## 35 Industrial Way - permit #1971

I have started review of your application to establish brewery and tasting room at 35 Industrial Way.

SHEET TITLE:
FIRST FLOOR PLAN

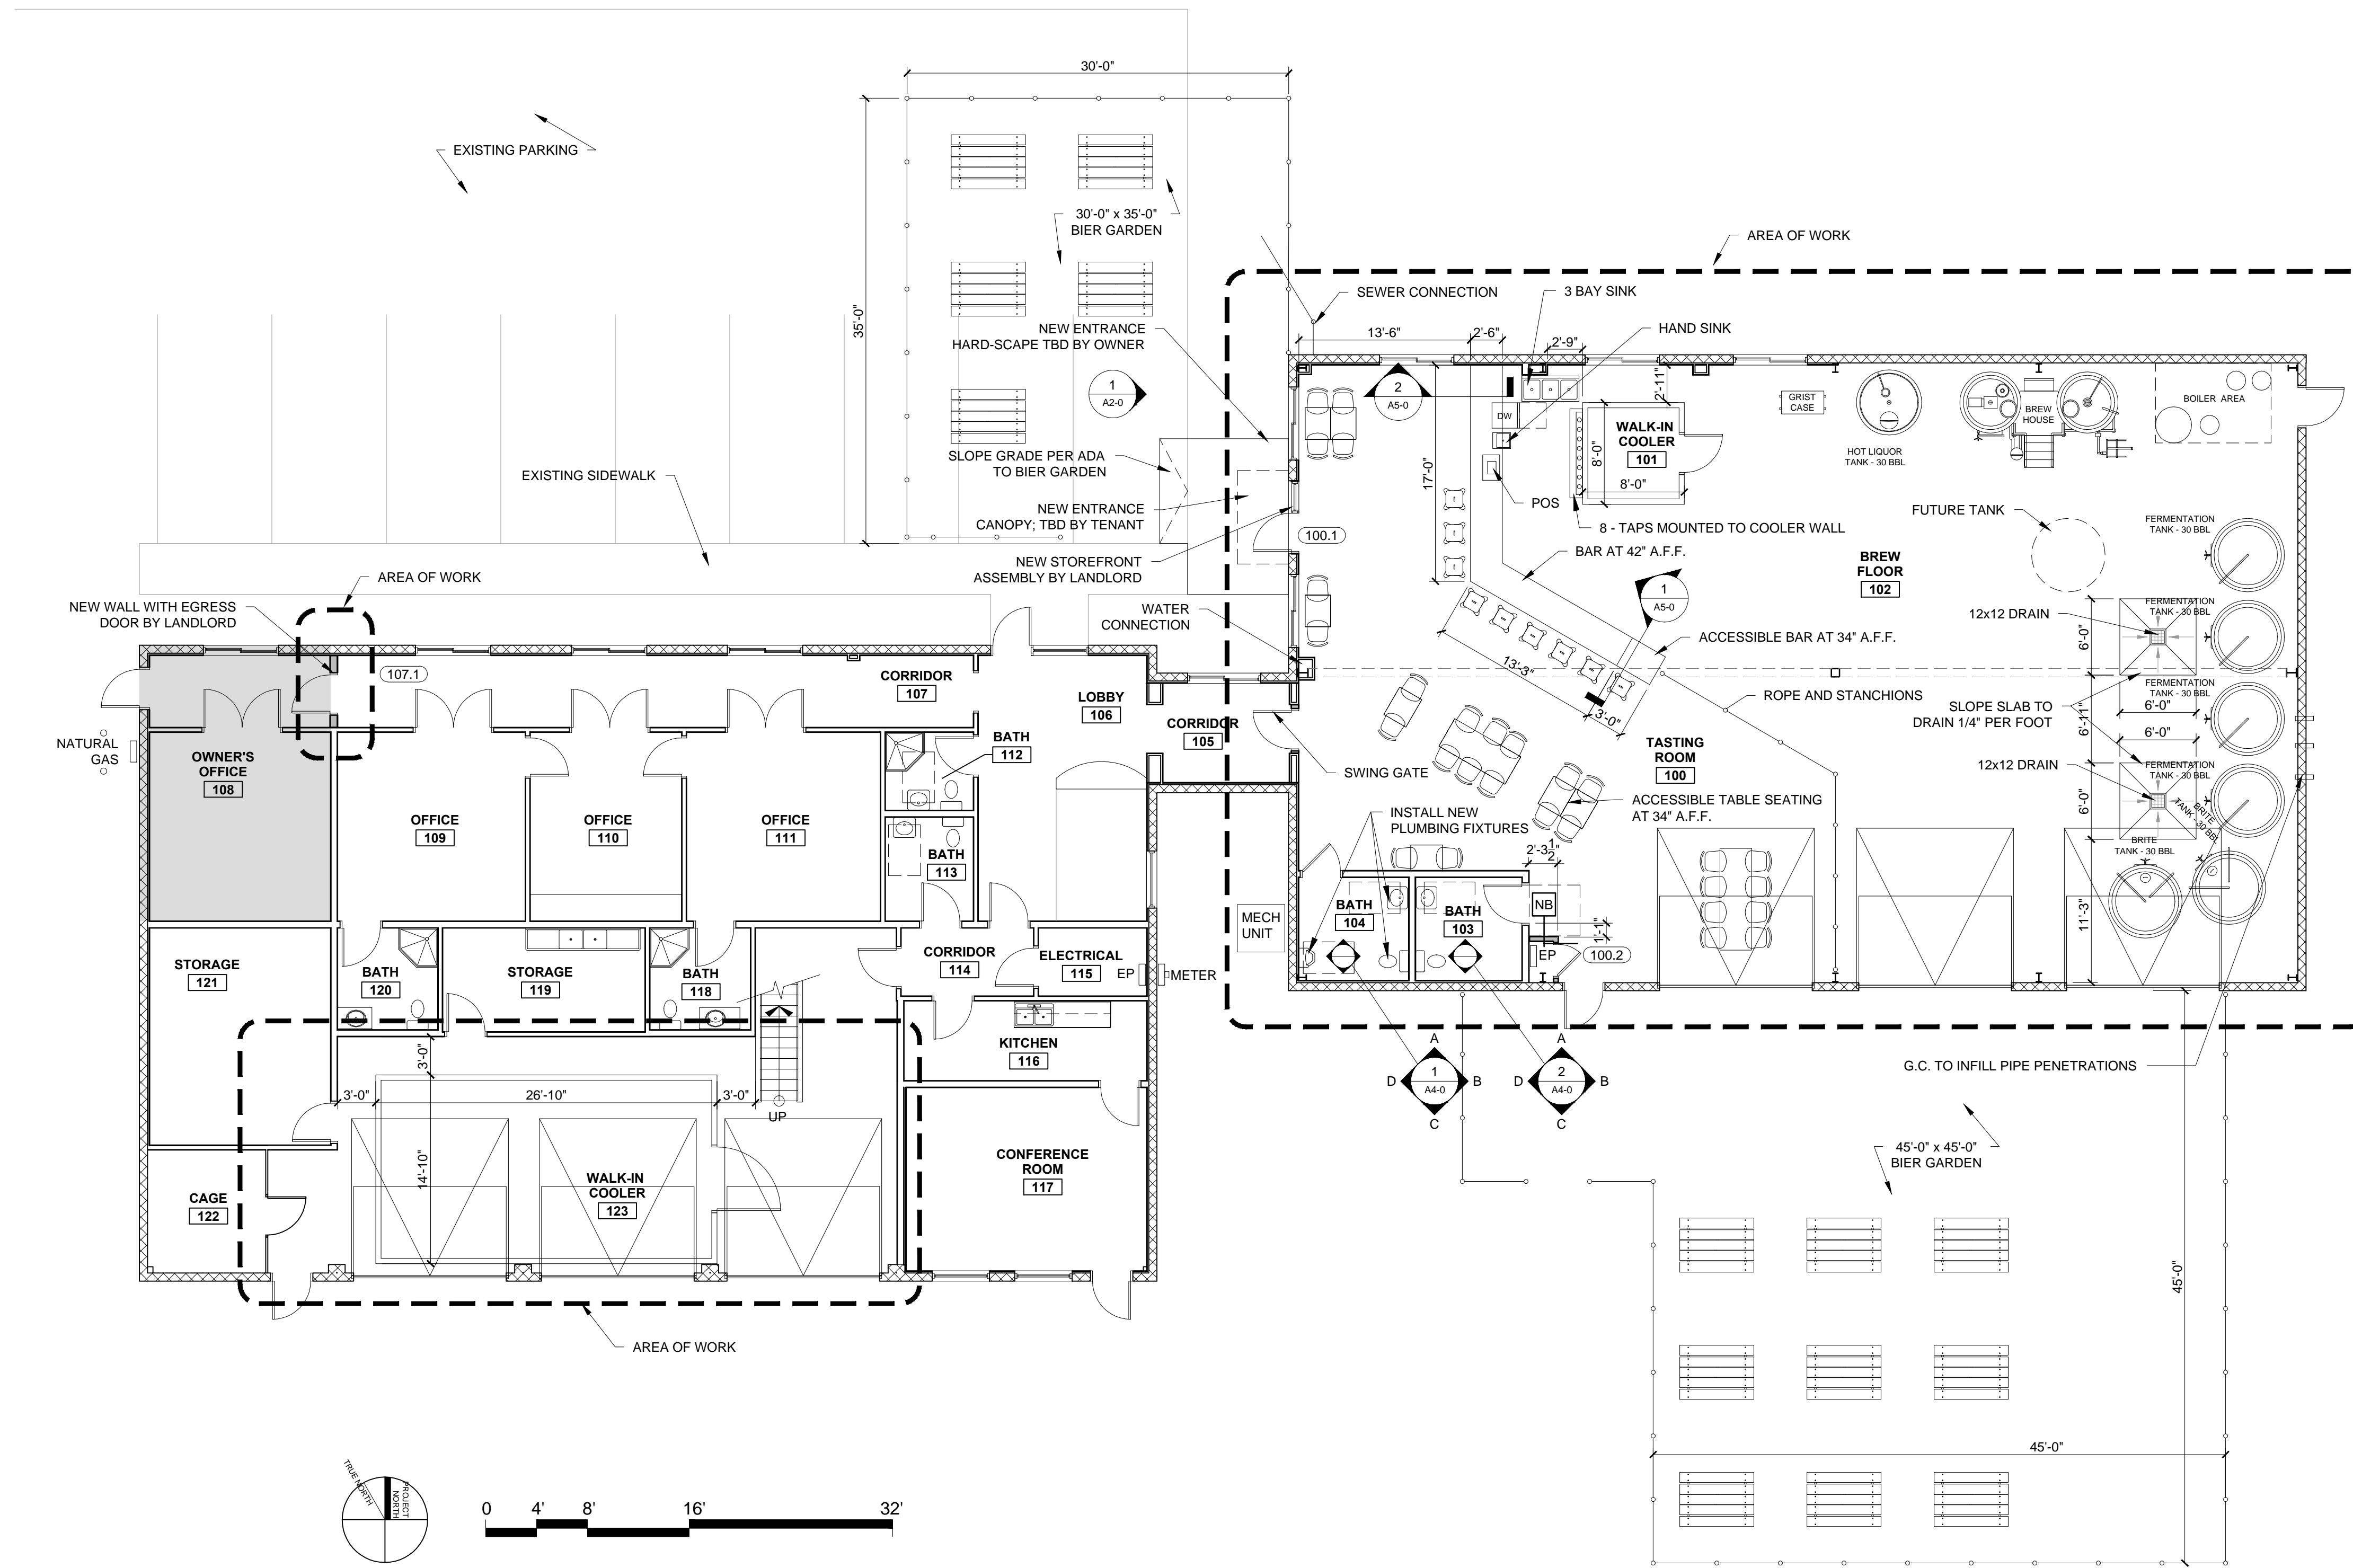
I had a couple questions regarding parking on the property. It looks like at least seasonally, the front parking and a portion of the rear parking may be taken up with an outdoor beer garden use. Do you know approximately how many parking spaces will remain available outside of those beer garden areas? Also, is there any plan to alter the parking lot such as by striping new spaces where it was formally used for outdoor storage? This type of work may require a minor approval through our Planning Department which I am happy to help coordinate with you and/or the landlord if needed.

We measured 130 feet for spaces along the right fence and up to 180 feet for spaces along the back fence. Based on these dimensions and the space size requirements, we can have 20 standard spaces along the back fence, and 15 spaces on the right fence (8 standard and 7 compact). We will also consider up to an additional 15 spaces on the back right side of building - would look at a double bank if we have enough minimum required through way. Also, our understanding is that we will require 3 handicap spaces, including one van accessible. These spots, along with 3 additional standard spots will be located in the front of the building to the right of the front bier garden.

Regarding painted lines, in this a requirement or a suggestion? If required, once we get an approved layout, we can start getting quotes for painting and can make that happen.
